Please ask for: Ms Iqraa Malik
Email: iqraa.malik@terraquest.co.uk
Telephone: 0121 234 1390
Our Ref: AL/54/22/HH
Your Ref:
Date: 29th April 2022

Application for Planning Permission for Works or Extension to a Dwelling

Development: Creation of first floor with 2 x rear dormers with juliet balconies and 3 x front rooflights, erection of single storey rear extension, summer house to rear, installation of car port to front and alterations to fenestration.

Location: Dove Cottage Nyton Road Westergate PO20 3UN

Site plan

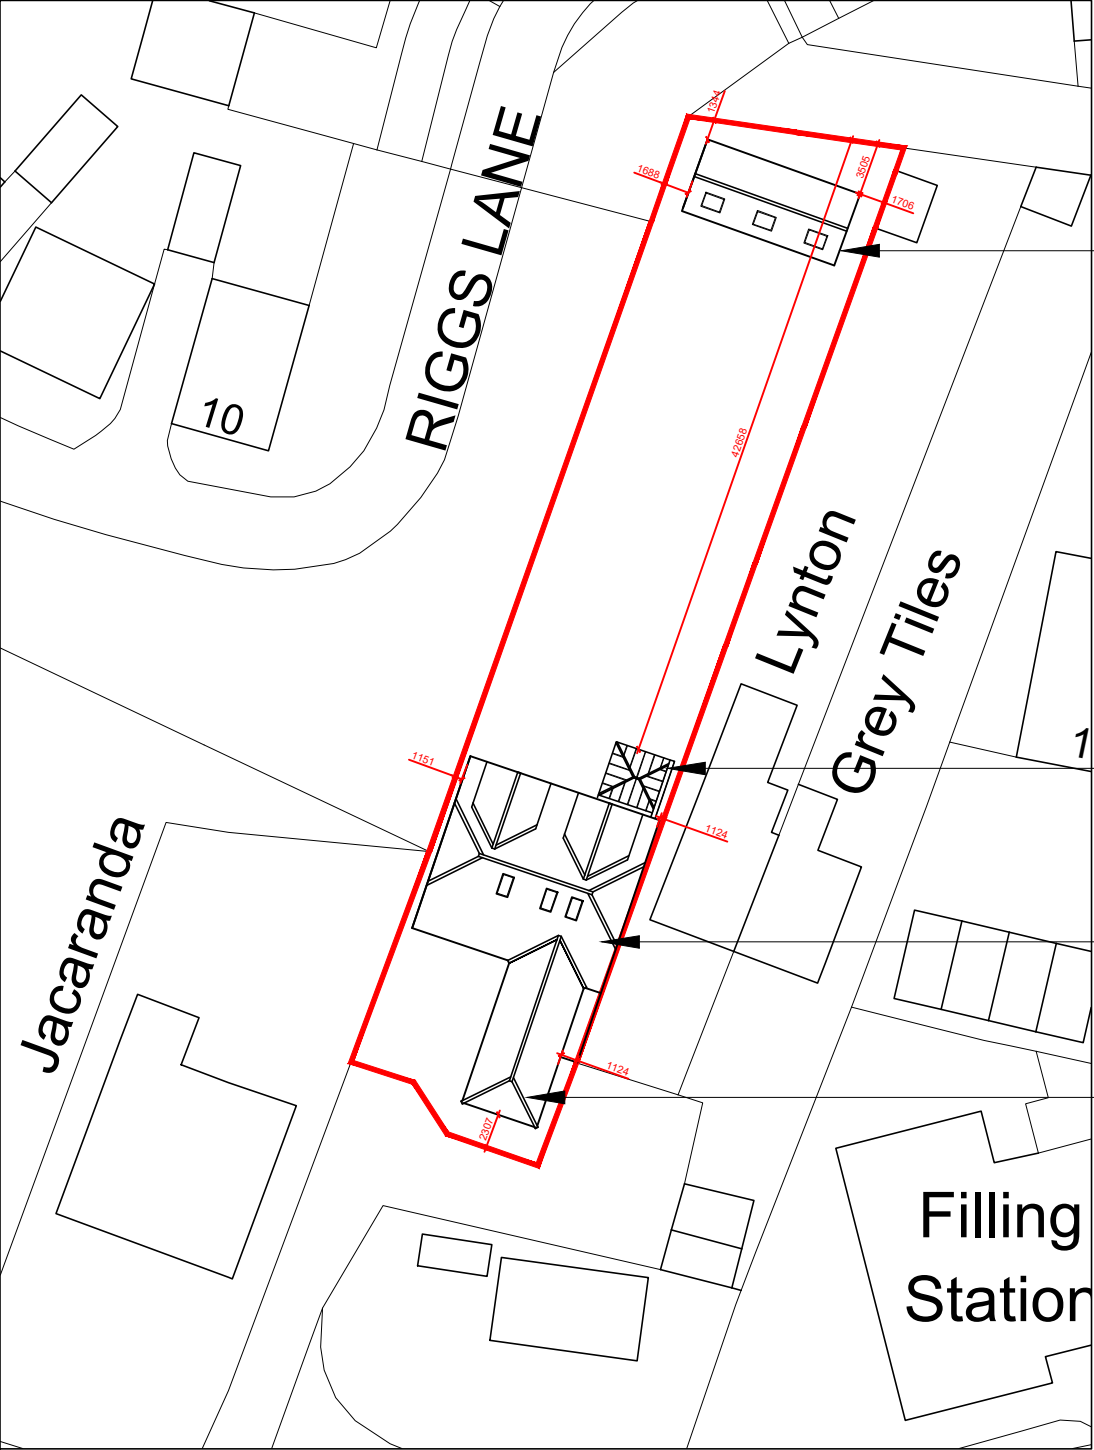
Block Plan

You are required to have dimensions from the proposed extension(s) to all site boundaries. Please amend
